CITY OF ALBUQUERQUE

**Re: Azar-Menaul Townhomes, Grading and Drainage Plan
Engineer's Stamp Date 5/17/2015 (H22/D078)**

Rudy, Please find the responses to your written comments dated 5/12/16. The initial comments area in black and our response as to how we addressed are in blue:

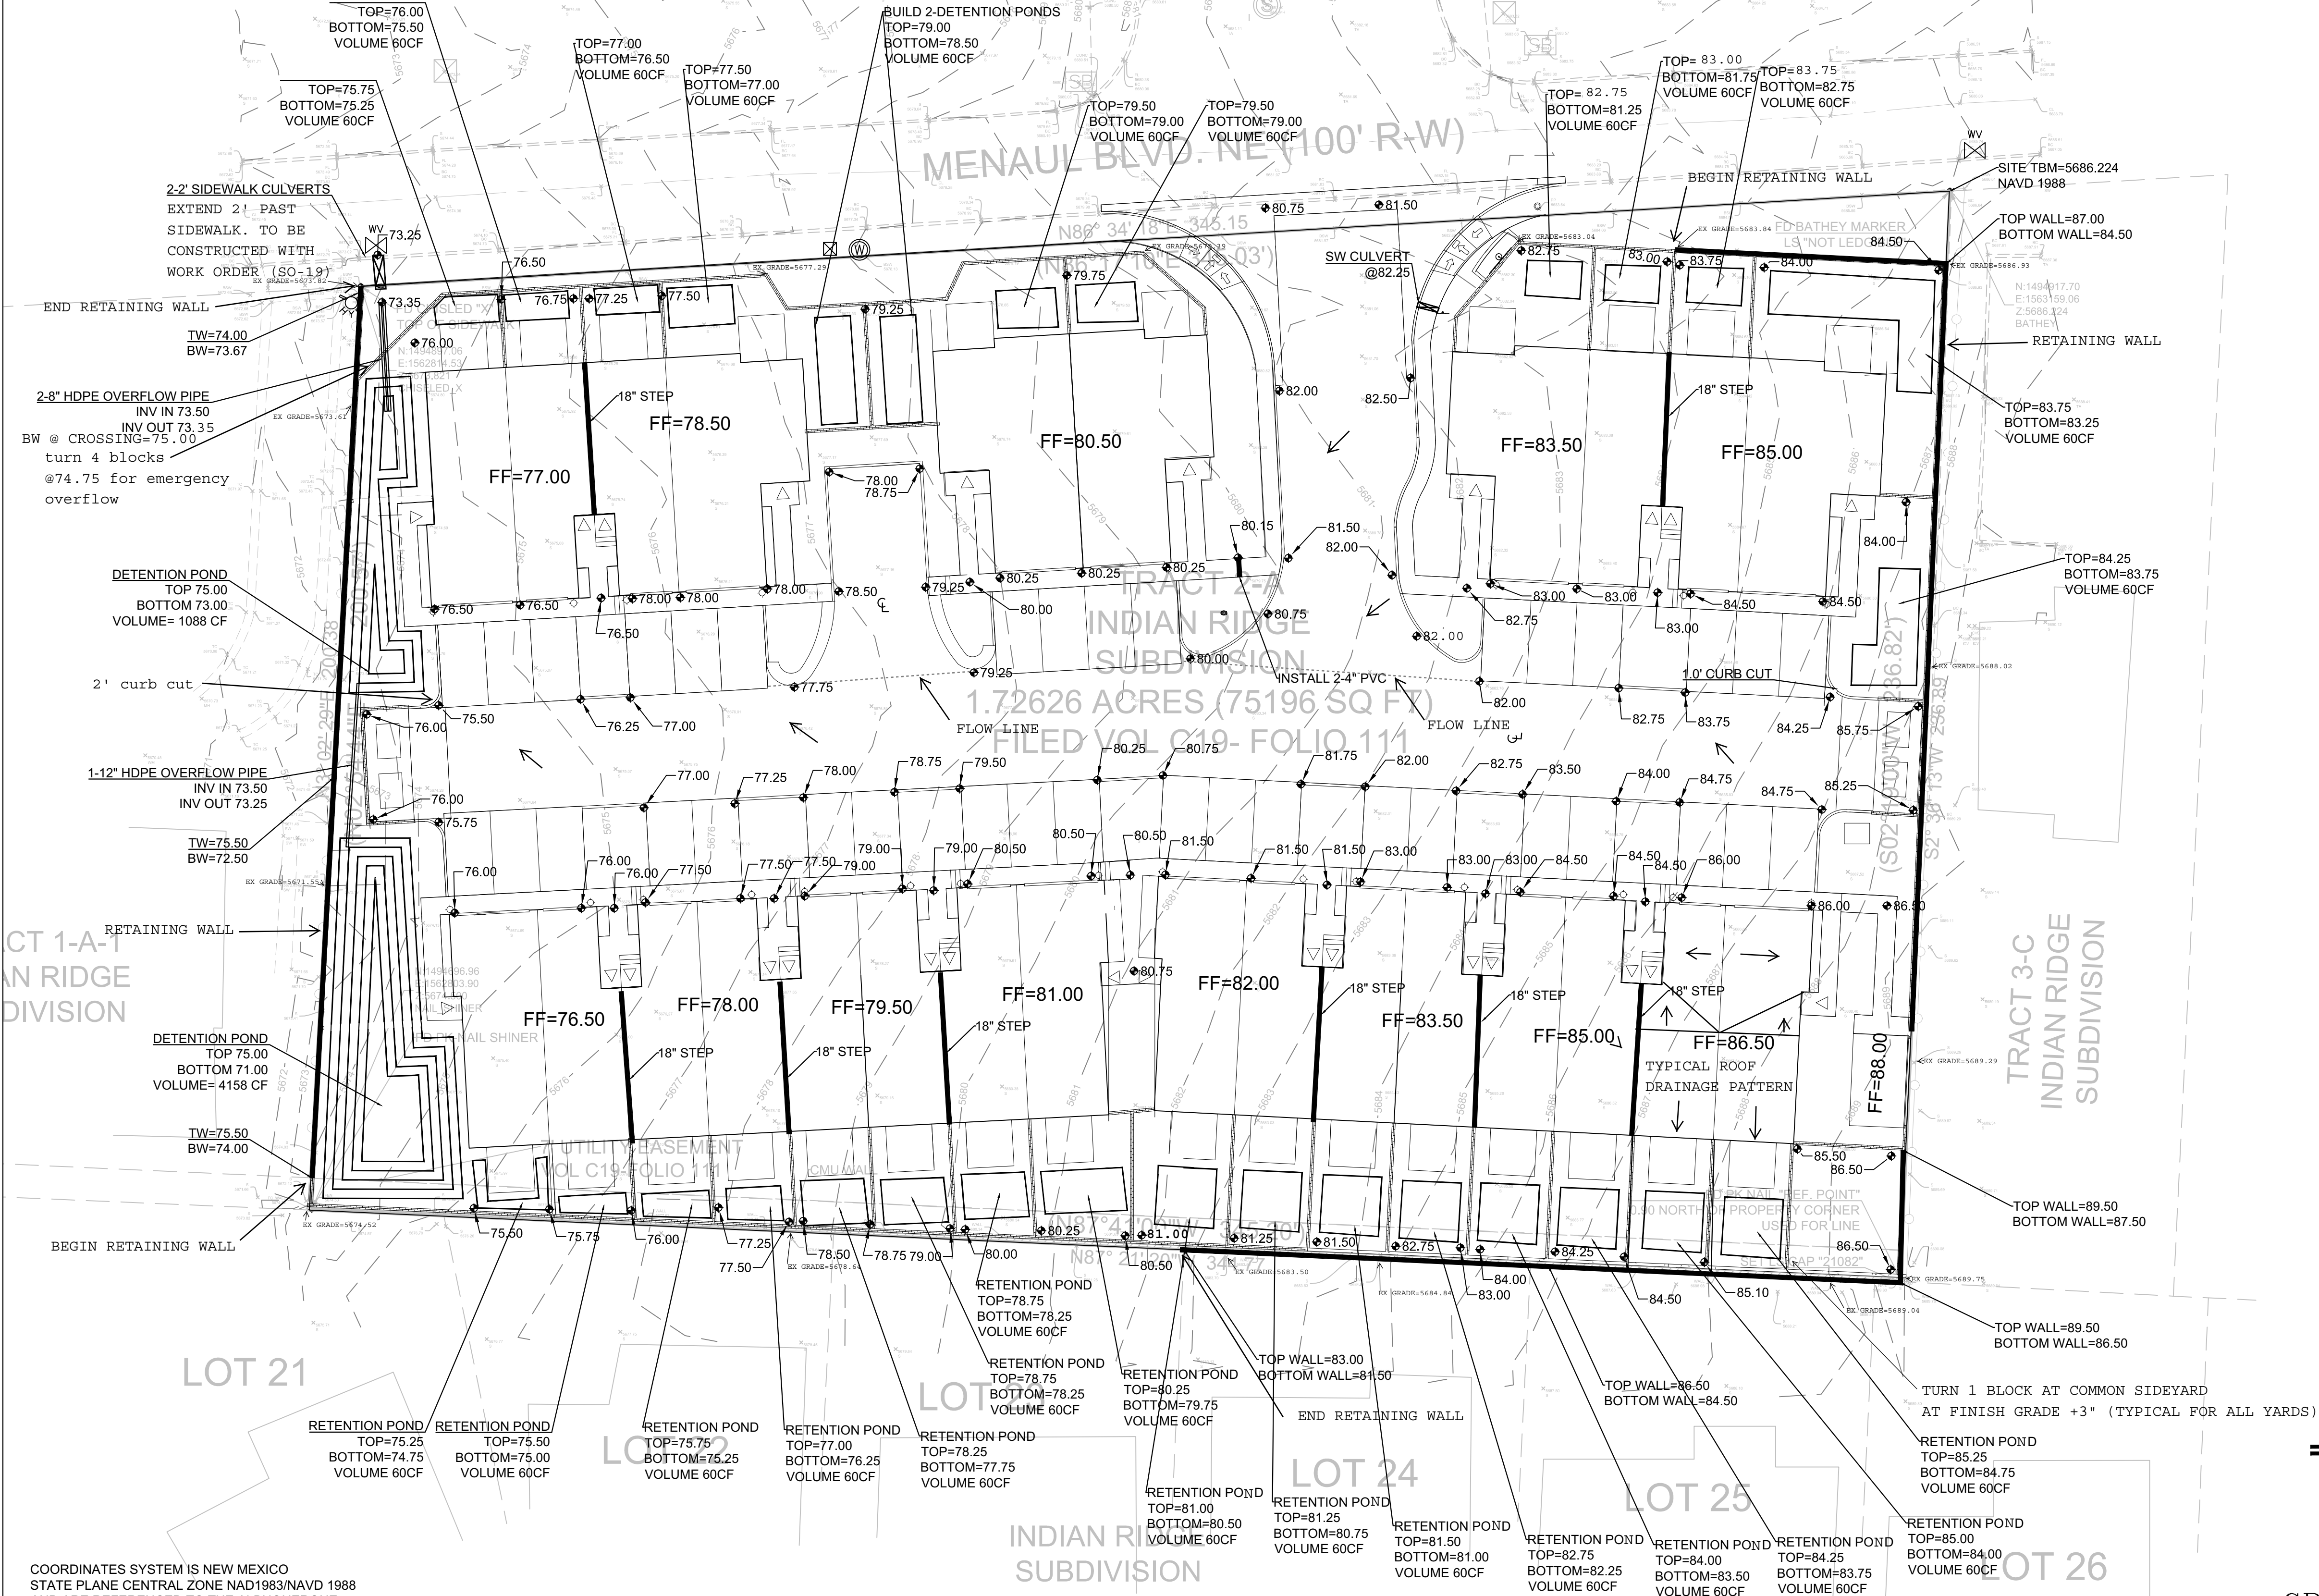
- There are some darkened lines throughout the site, are these all retaining walls?
YES, I HAVE ADDED LABLES TO CLARIFY, WE HAVE TOP AND BOTTOMS CALLED OUT

- Provide a detail where the block wall and the 8" HDPE intersect each other.
I HAVE ADDED NOTE TO PLAN TO CLARIFY THE PIPE RUNS UNDER WALL
BOTTOM OF WALL=75.00, TOP OF PIPE=74.00

- Provide elevations around the exterior of the perimeter.
I HAVE ADDED
- Show roof flows.
THE ROOFS ARE PITCH SO I HAVE ADDED ROOF DRAIN PATTERN ON SE BUILDING
AND LABELED AS
TYPICAL

- The NW corner of the sites spot elevation is higher than the invert out, please correct.
WE HAVE CORRECTED THIS TYPO.

**SHEET STRUCT001**  
INDIAN RIDGE PATIO HOMES  
11,910 MENAUL BLVD. N.E.  
ALBUQUERQUE, NEW MEXICO  
**SITE WALLS PLAN**

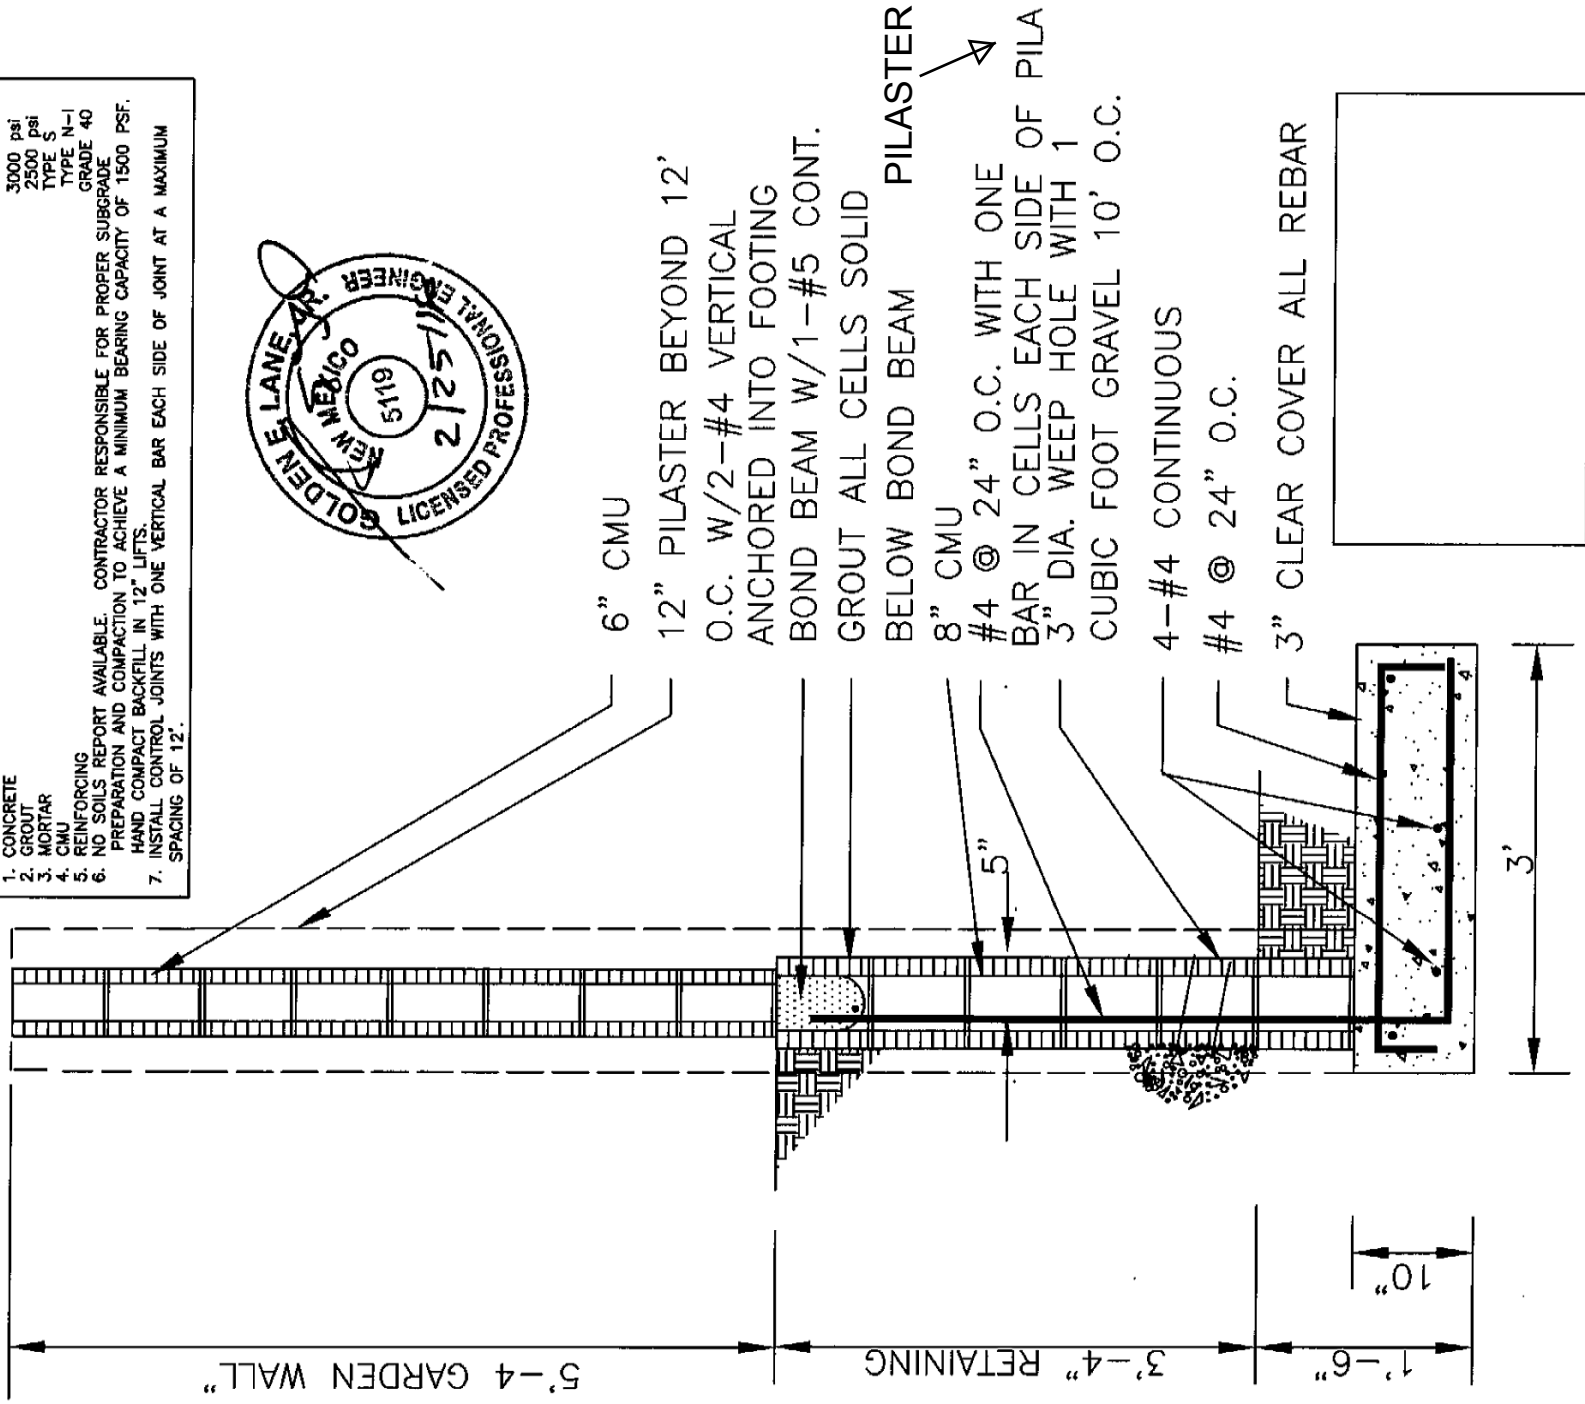
- Provide a detail for all retaining walls.
I HAVE ATTACHED, THESE ARE PART OF SEPARATE PERMIT
- How will flows leave the back yards? Provide turn blocks 3" above grade.
WE HAVE ADDED TO NOTE TO PLAN AND ADDED TO NOTE#3
